Regarding correspondence dated 12 January 2021:

Applicant:	Dunkenhalgh Estate
Planning App. No.:	3/2020/1103
Grid Ref:	370978 433702
Proposal:	Proposed replacement dwelling
Location:	Overdale York Lane Langho BB6 8DT

**Sun Path Analysis**  
**May**  
**Existing**  
53.798872N -2.442115W

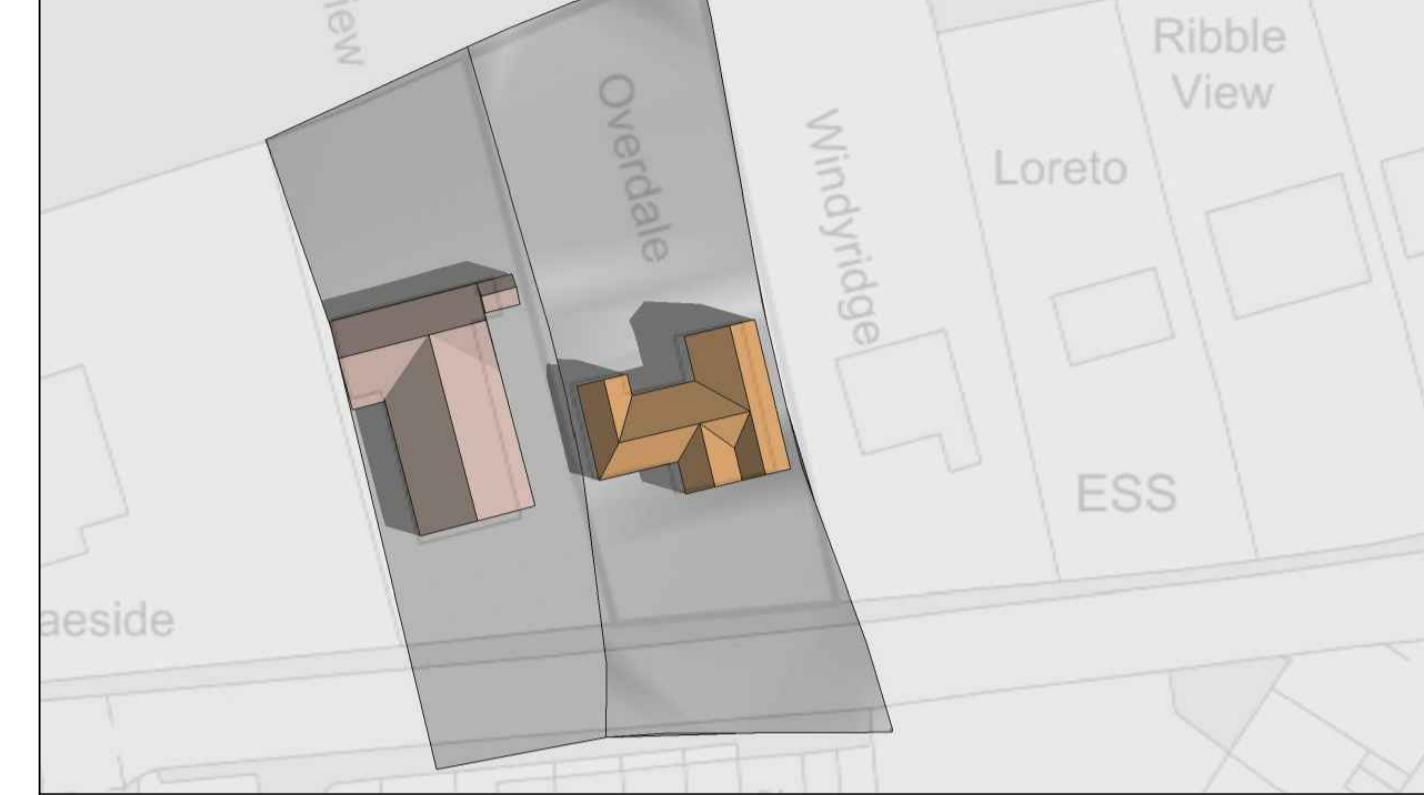
- Whilst I appreciate that the proposed plans aim to mitigate any height differential between the current dwelling and the proposals, I am not certain from the plans whether there would be an adverse impact to the light into my property. I would strongly oppose any loss of light and ask that the plans be revised to assure that this is not the case.
